**KIRKLEES METROPOLITAN COUNCIL
INVESTMENT & REGENERATION SERVICE**

Reference No: 2019/70/90648/E

Site Address: Red House, Bristfield Road, Bristfield, Dewsbury,
WF12 0NX

Description: Variation condition 2 (plans) on previous permission
2017/90677 for demolition of existing dwelling and
outbuilding and erection of new detached dwelling
with attached garage

FRONT ELEVATION

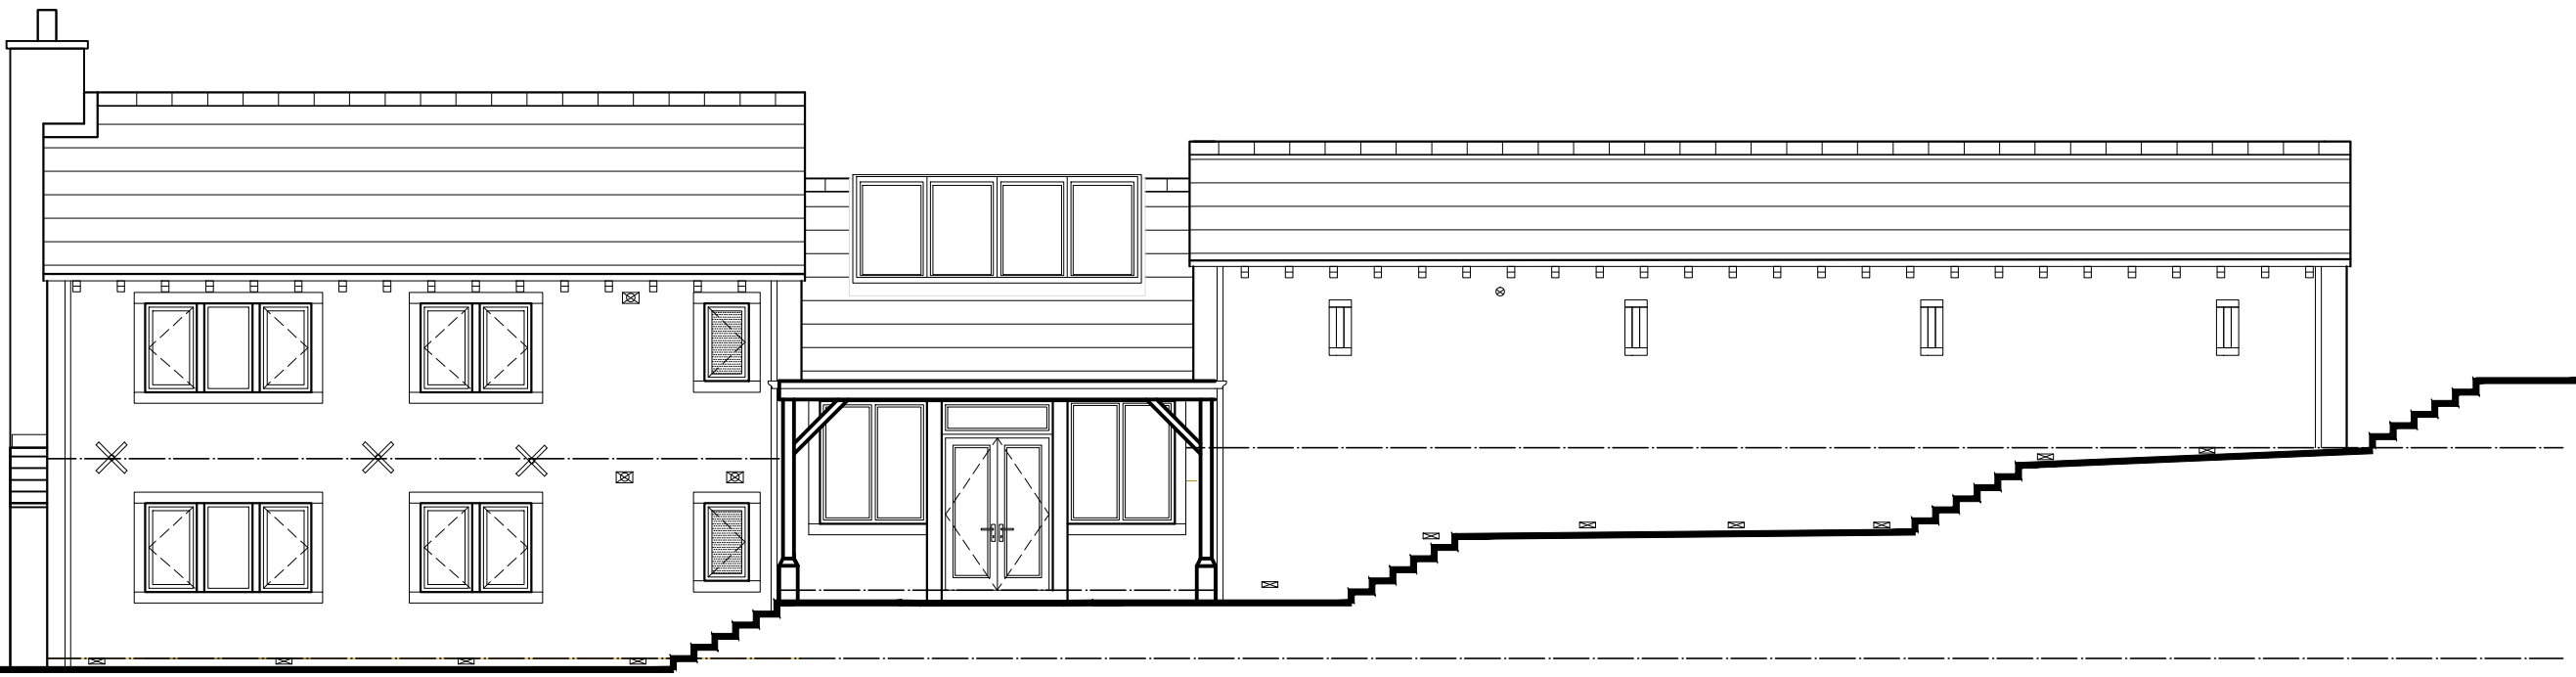
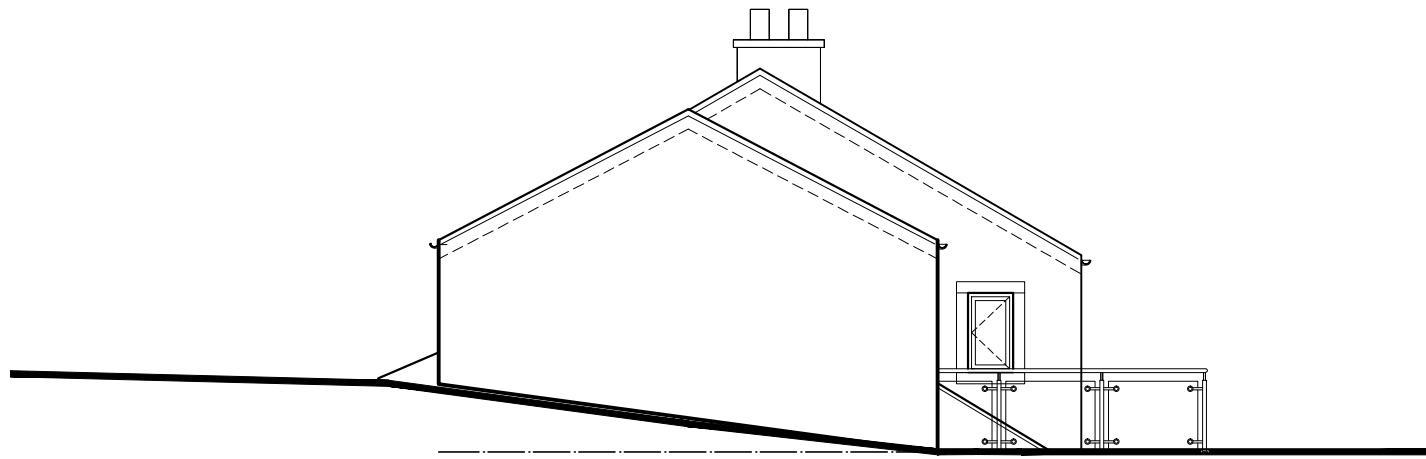
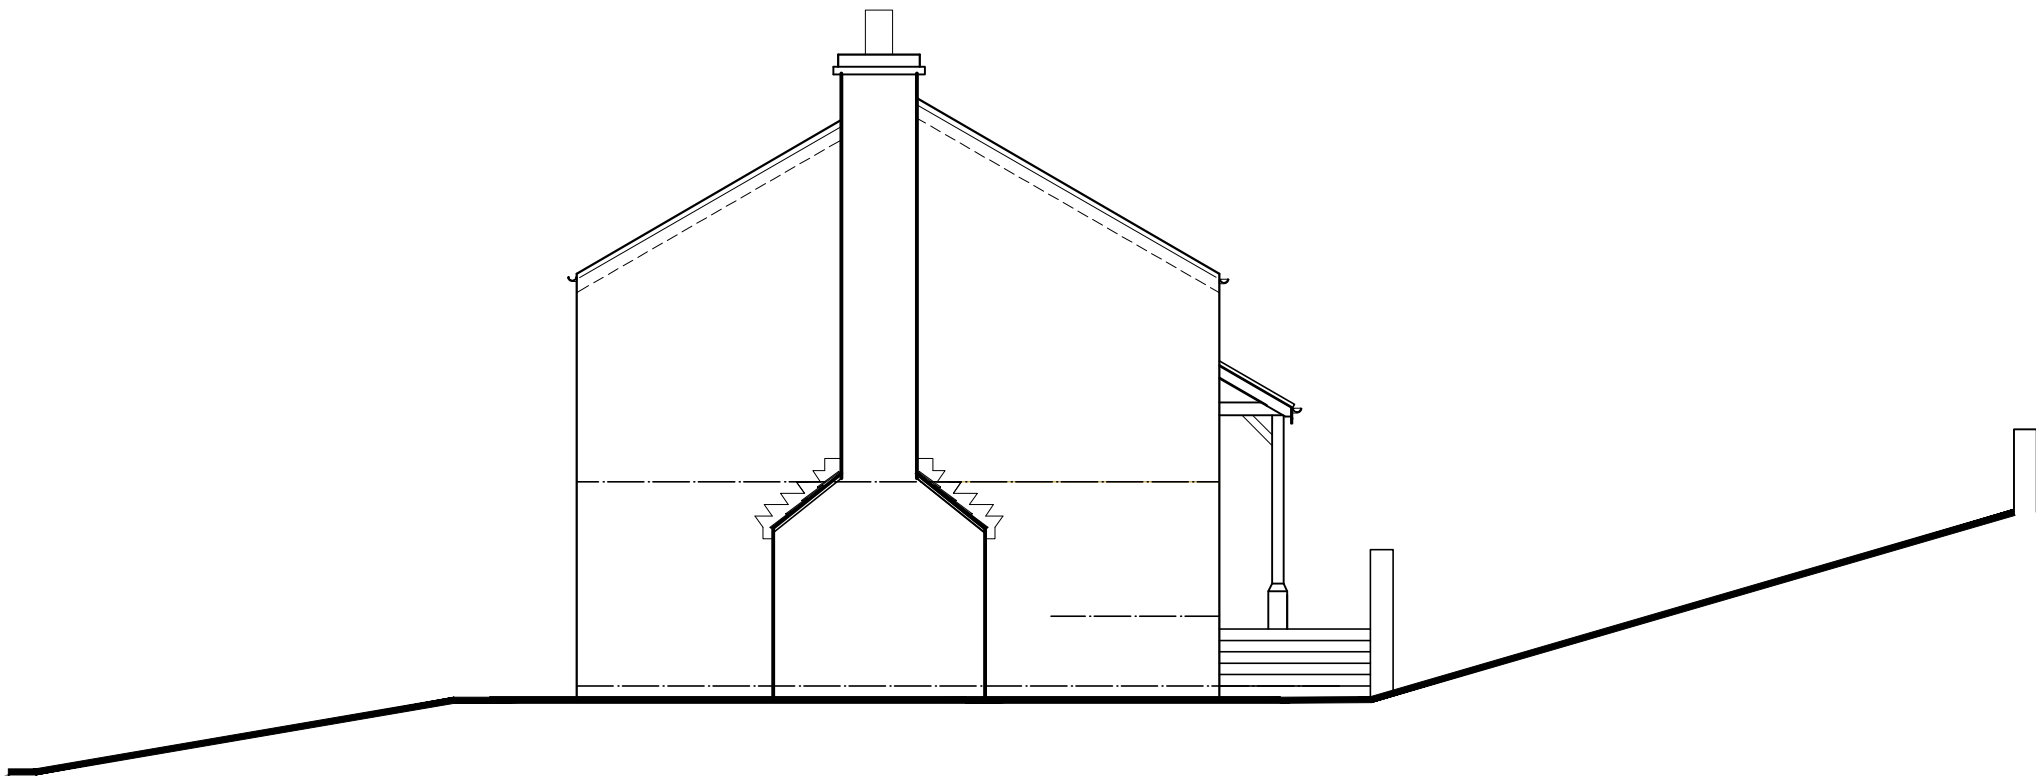
Other amendments to the application comprise a slight increase to the height of the roof of the link element, alterations to the fenestration and the removal of the water tabling to the roof.

24/04/19 Amended plans received showing the ridge height of the link extension reduced and the fenestration to the front altered after concerns raised by the officer.

The proposals would result in minor changes to the front elevation of the dwelling; however, following the submission of the amended plans, this would not affect the overall design and character of the proposed development.

The changes to the internal layout of the dwelling would result in an improvement to the way the space functions. There would be a slight increase to the height of the link element, however it would still retain the subordinate appearance which is an important factor in ensuring the development as a whole does not appear as one bulky element.

Pursuant to article 35 (2) of the Town and Country Planning (Development Management Procedure) Order 2015 and guidance in the National Planning Policy Framework, the Local Planning Authority have, where possible, made a pre-application advice service available, complied with the Kirklees Development Management Charter 2015 and otherwise actively engaged with the applicant in dealing with the application. A discussion took place with the agent regarding the proposed fenestration detail and the height of the link

element. An amended plan was submitted which addressed these issues, the decision and conditions is based on this amended plan.
